Re: Jersey Mike's Subs  
1624 NC 24-87 Highway  
Cameron, NC 28326

A-103
SHEET 3 OF 10

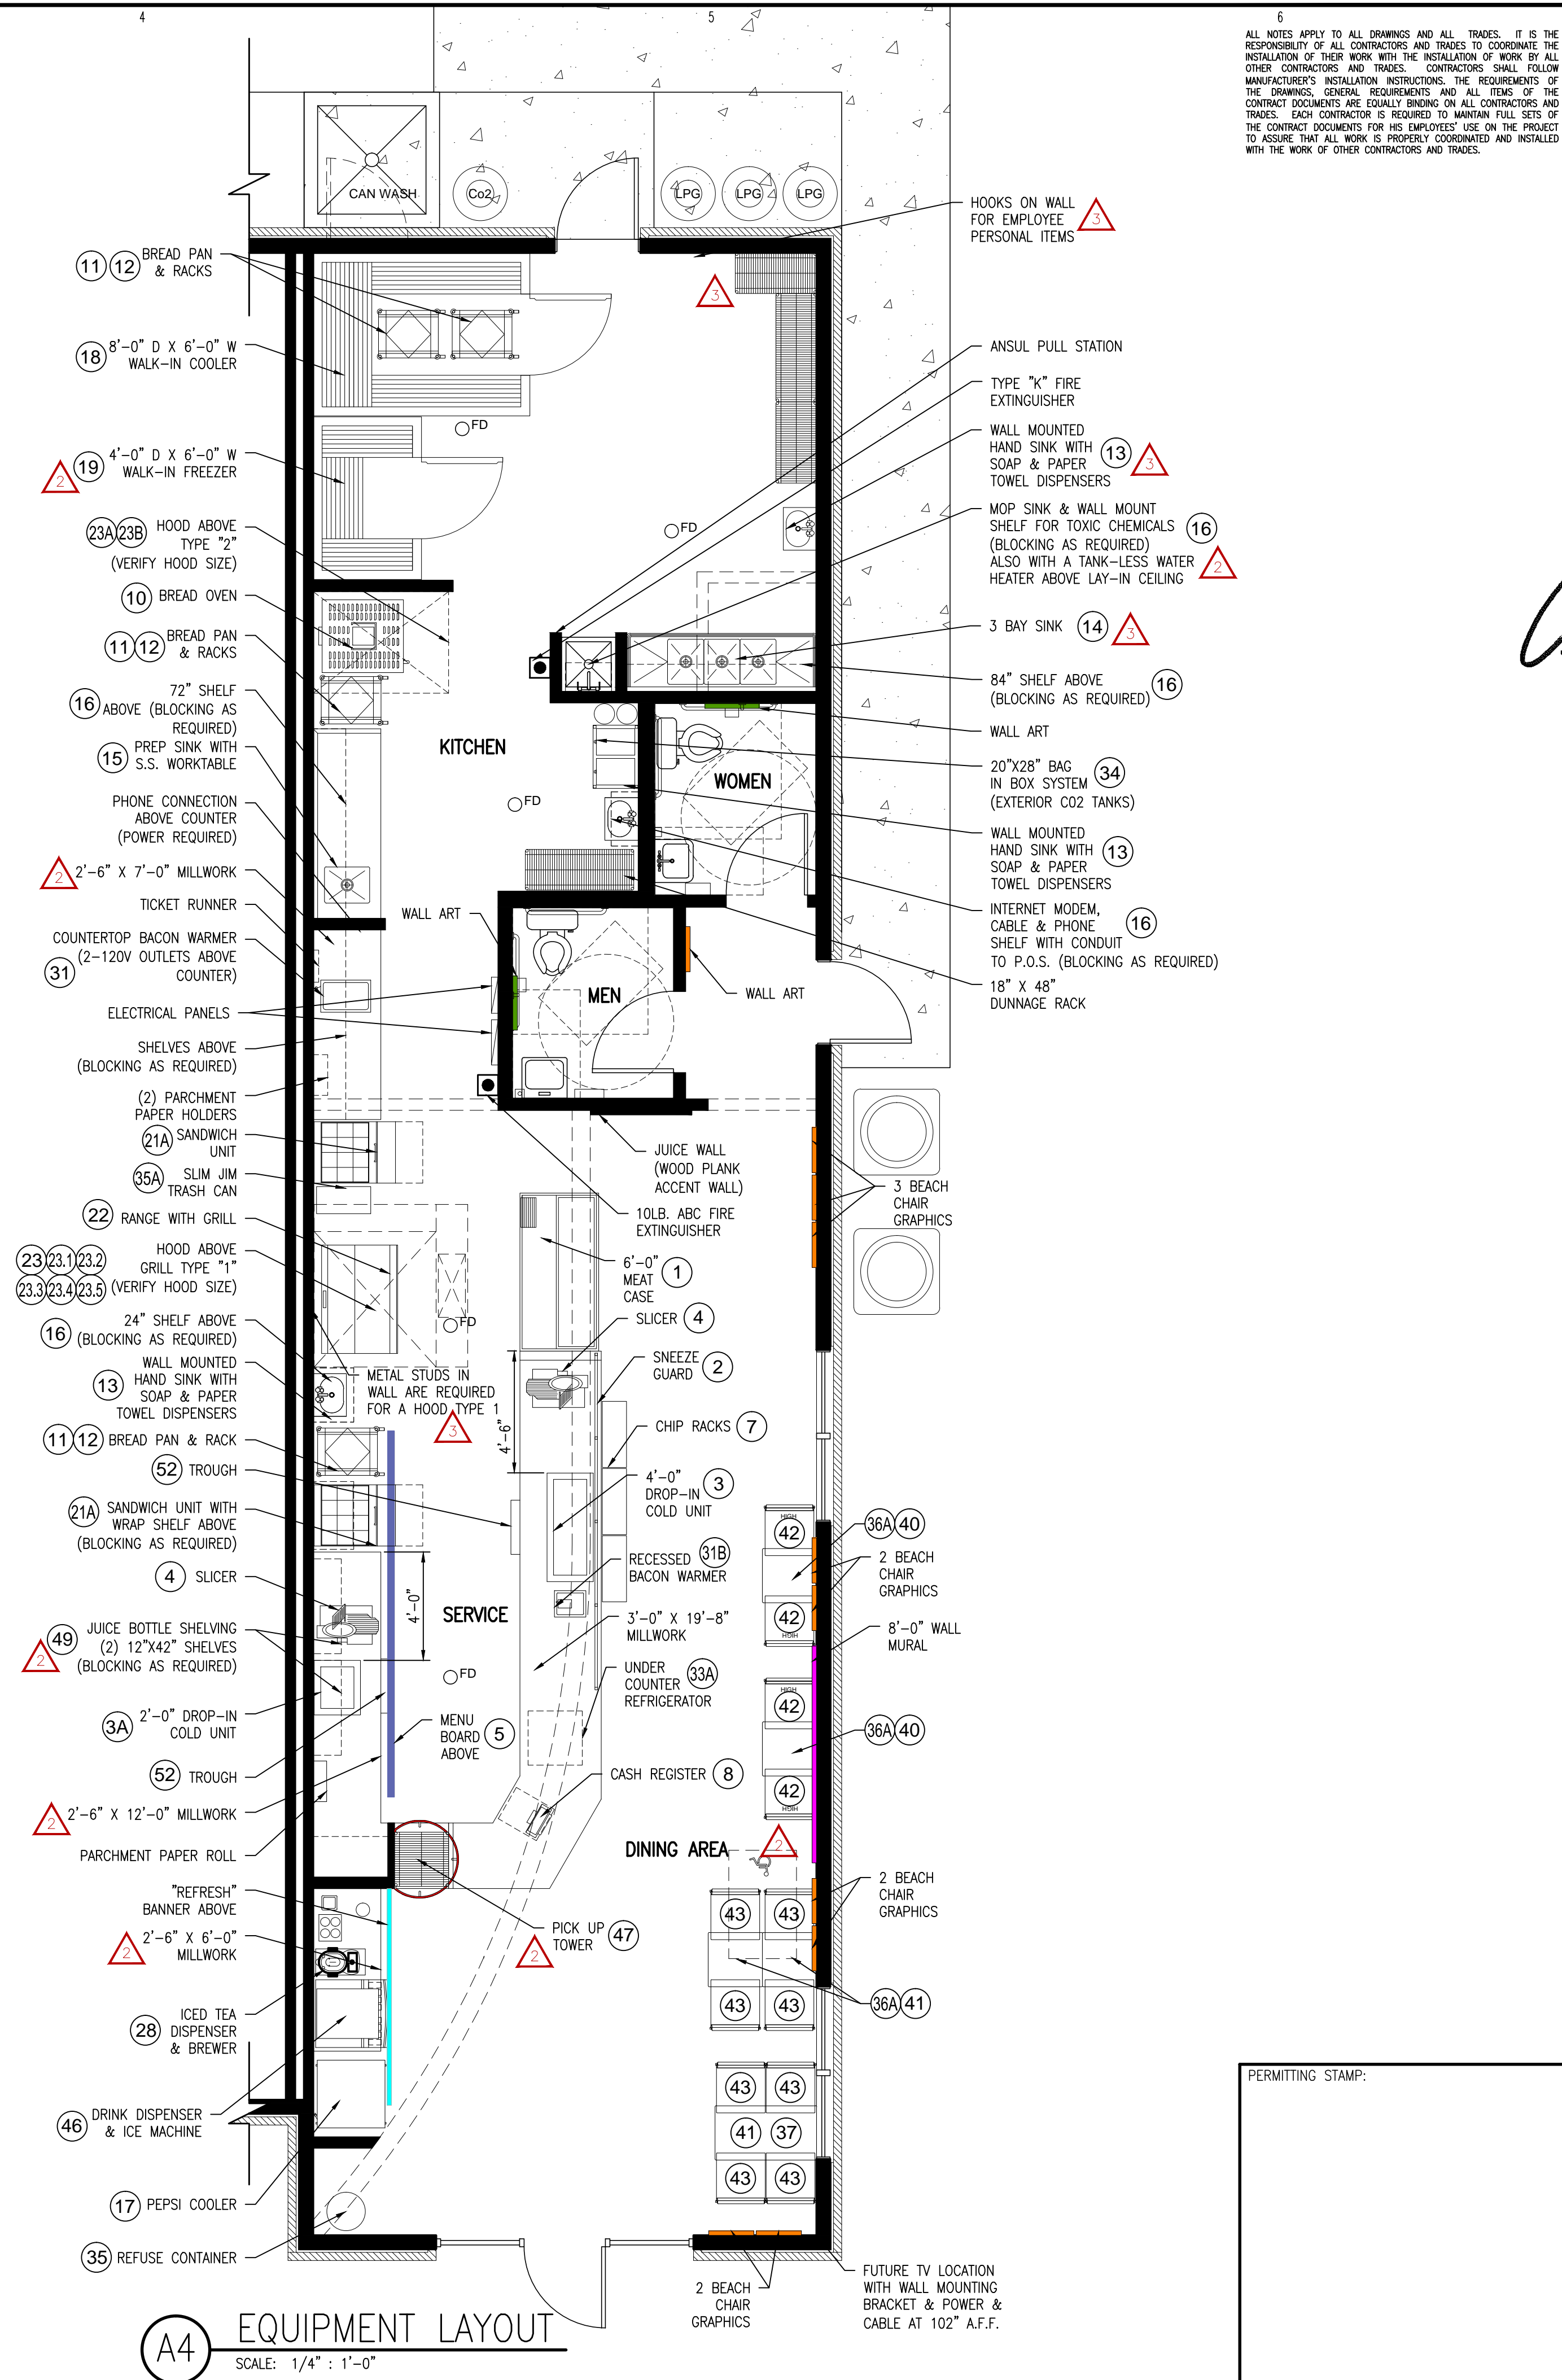
The 5-ton air handlers to sit on the proposed equipment platform only weight 170 pounds each. The method of framing and attachment of the equipment platforms/toilet ceilings with a ledger and joist hangers is perfectly acceptable. The minimum fastener for the ledger to studs would be two 16d nails. The Simpson SDWS timber screws and short-sapn 2x4 framing are more than adequate to support the wieght.
